A1 in Northumberland: Morpeth to Ellingham

Scheme Number: TR010059

7.13 Applicant's Response to Deadline 2 Submissions

Applicant's Response to Deadline 2 Submissions

© WSP UK Ltd

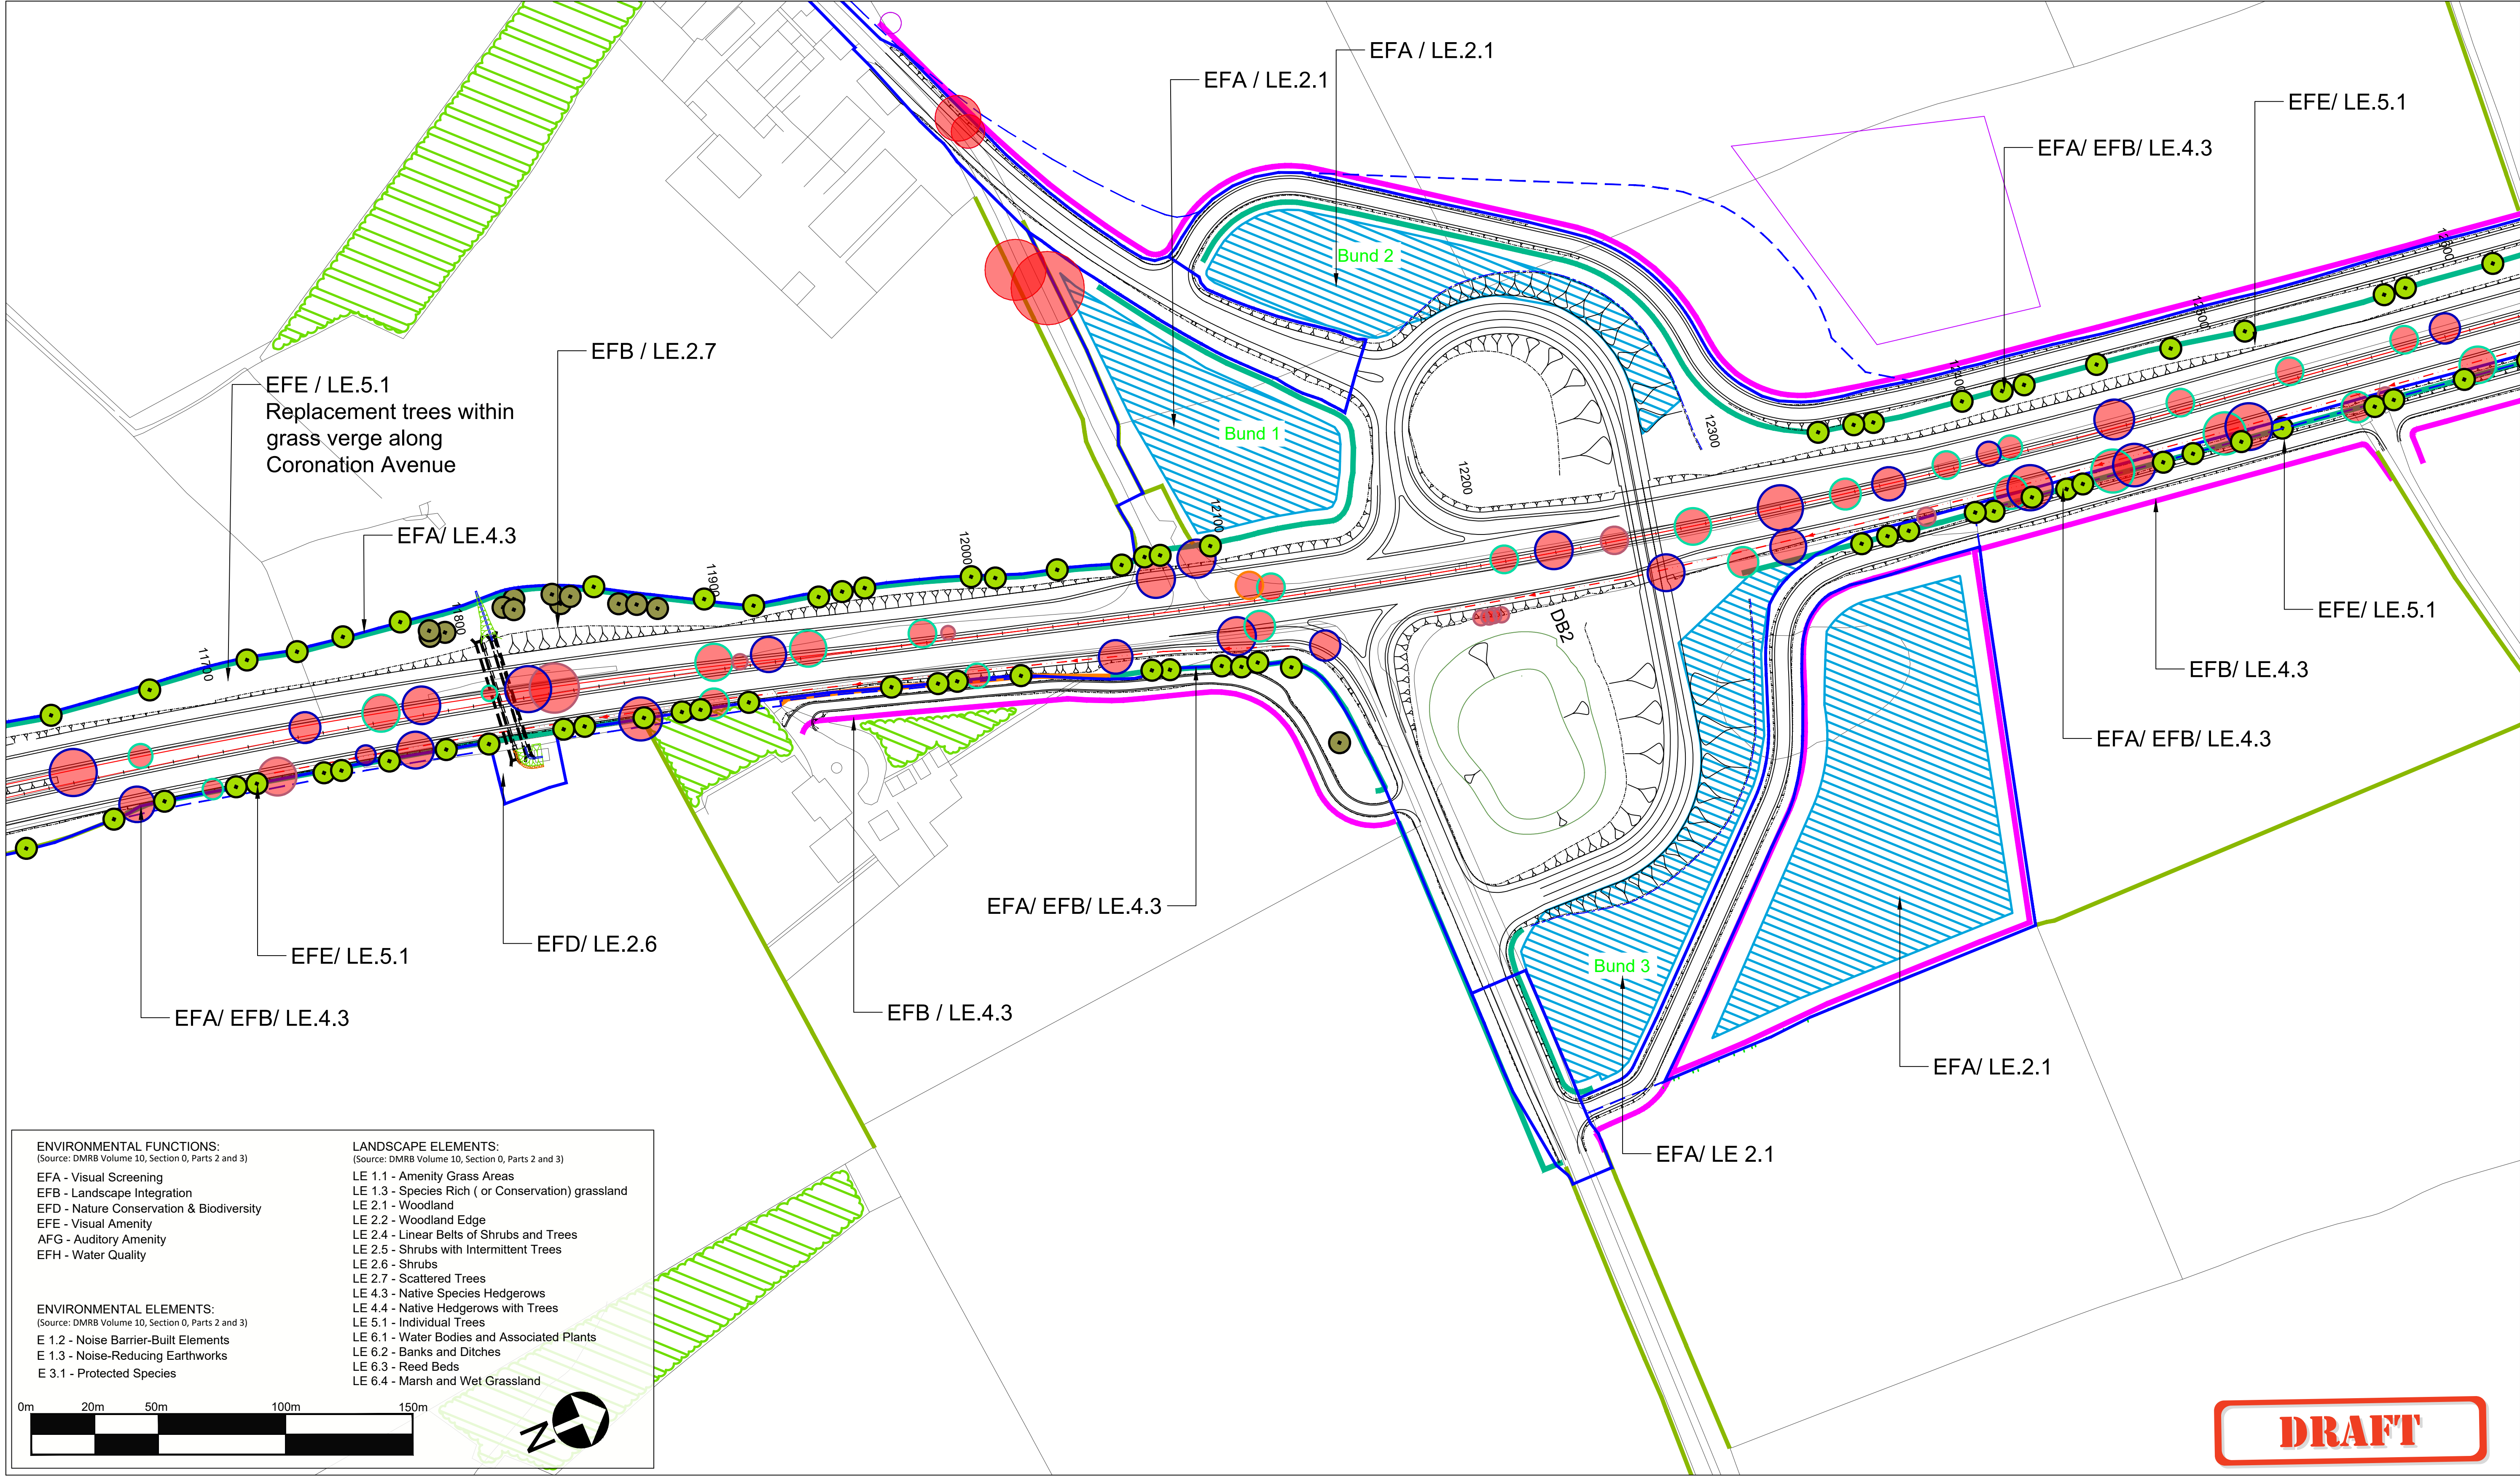
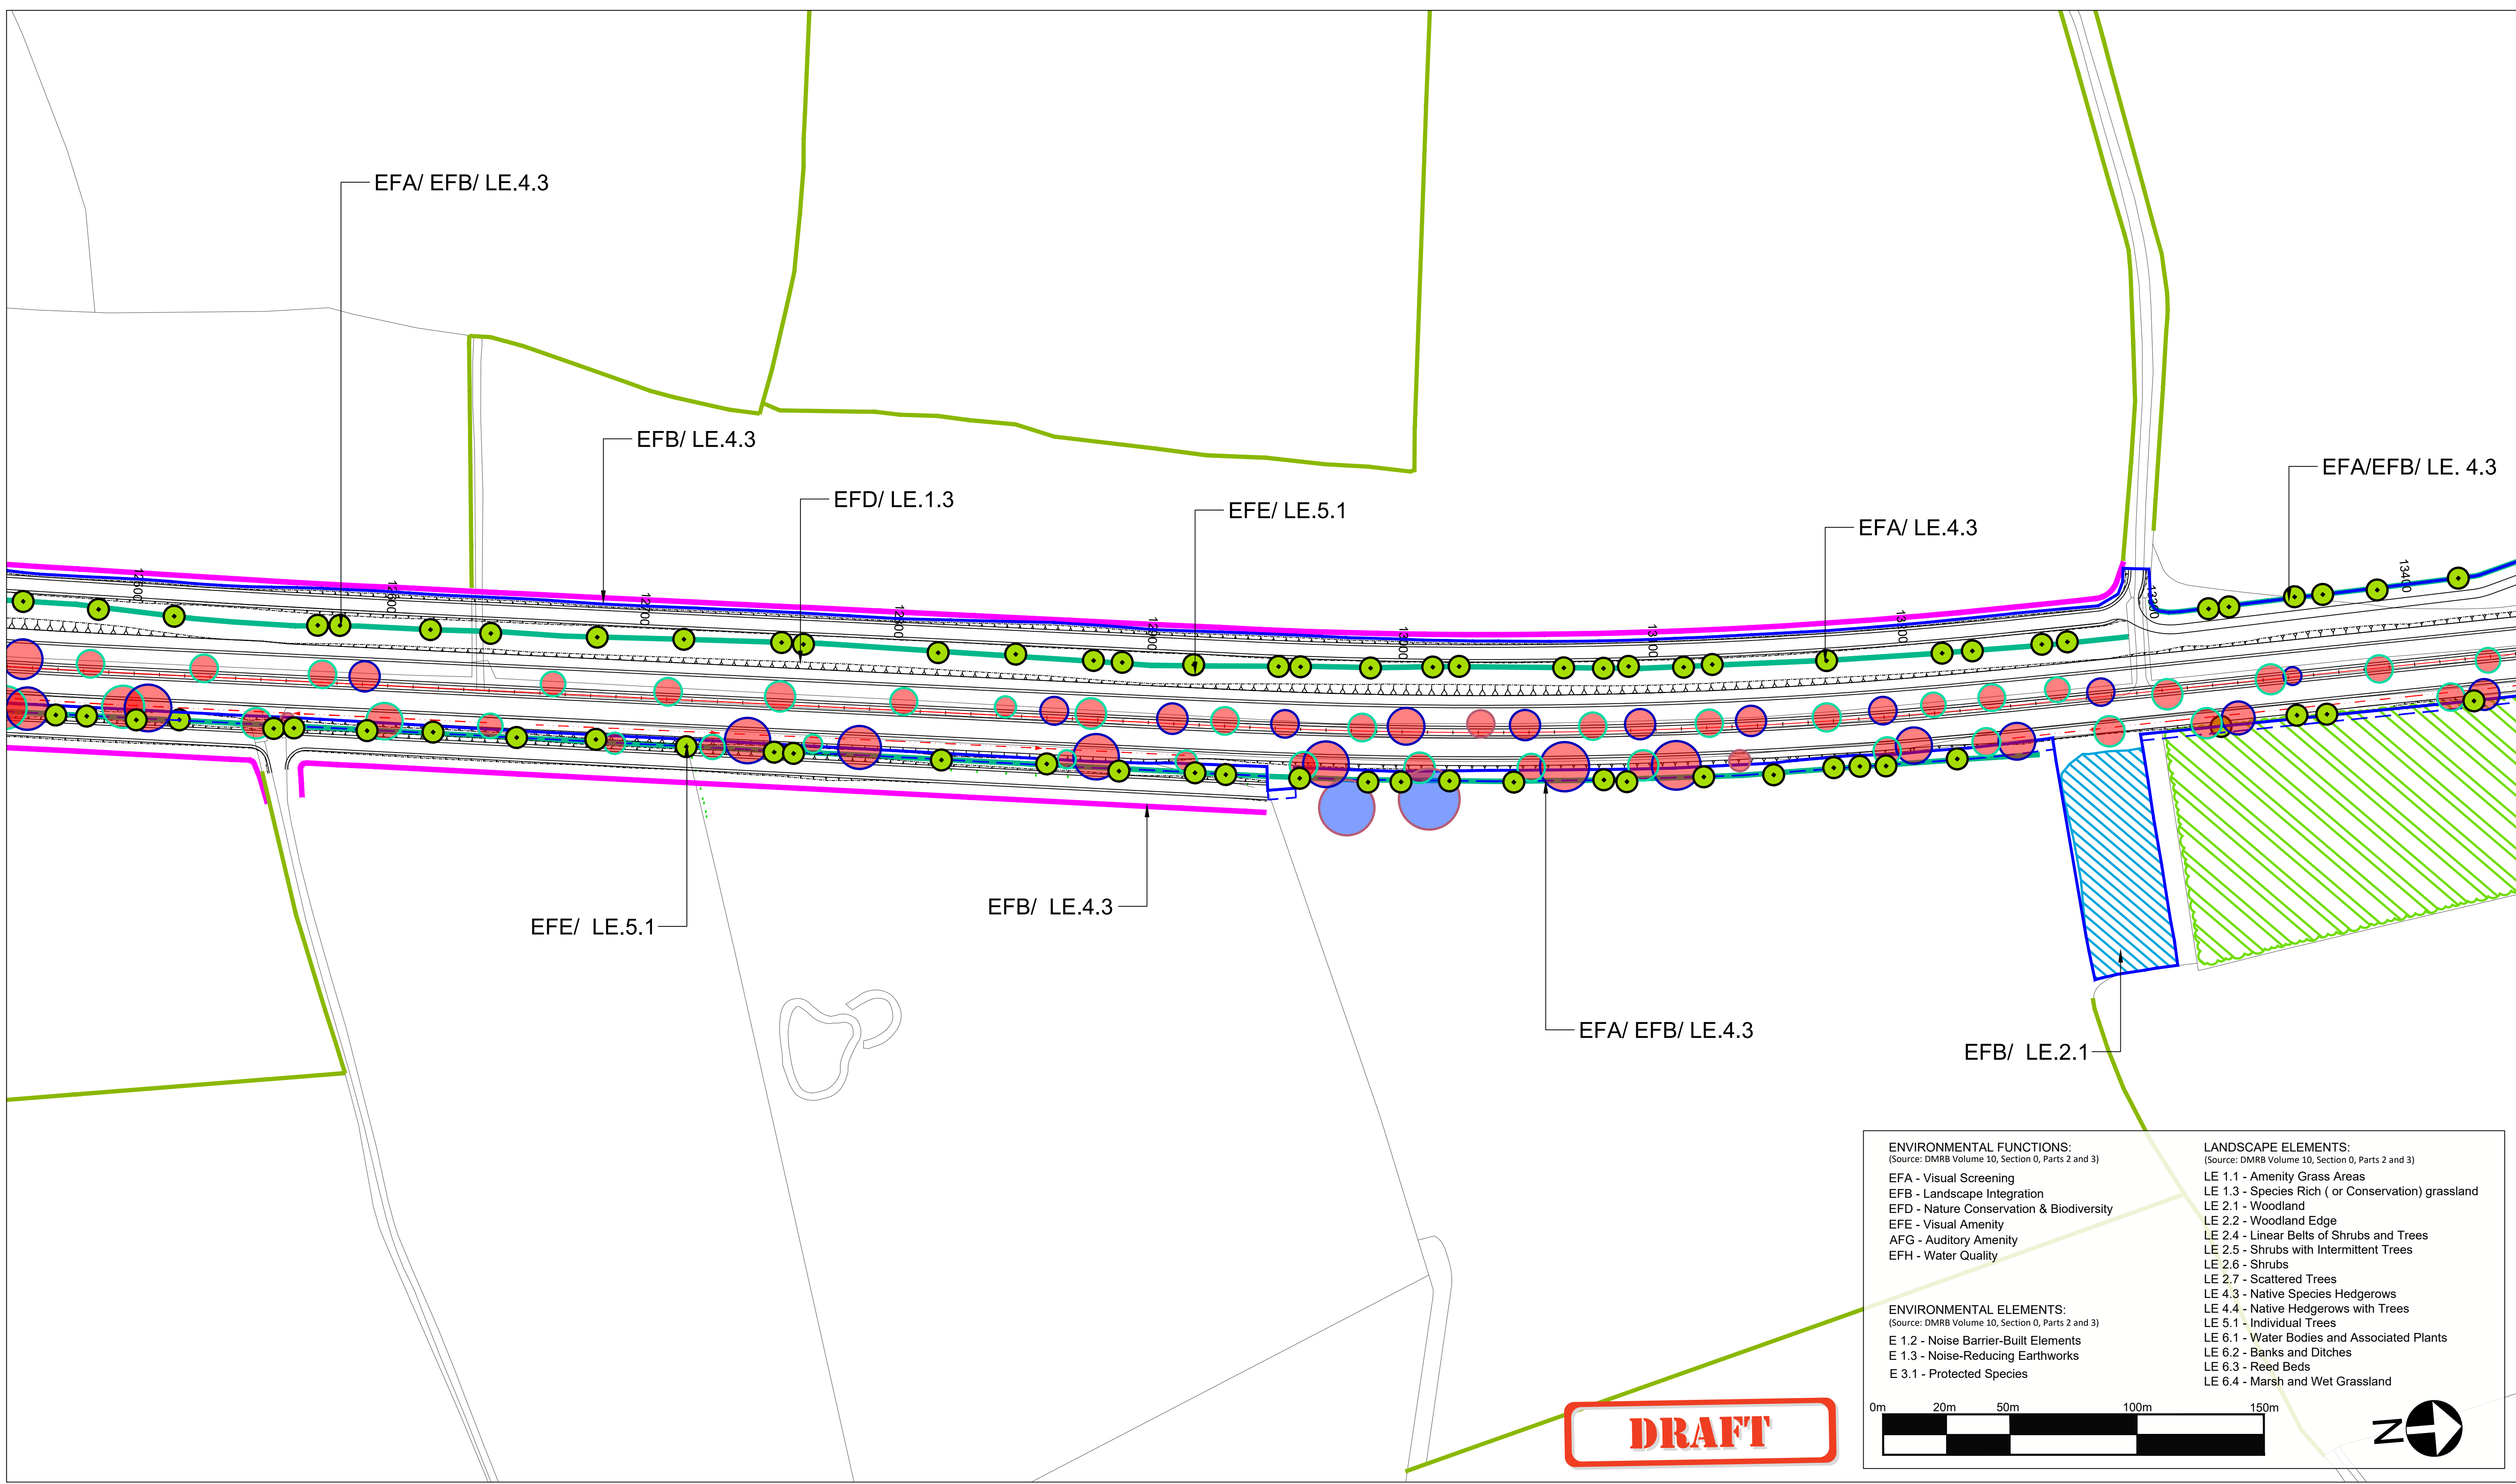
<p>Appendix LV.2 REP1-044</p>	<p>As previously reviewed and agreed.</p>	<p>1. It is noted that NCC are in agreement with Appendix LV.2 [REP1-044] which sets out the proposed approach to replacing trees at Coronation Avenue.</p>
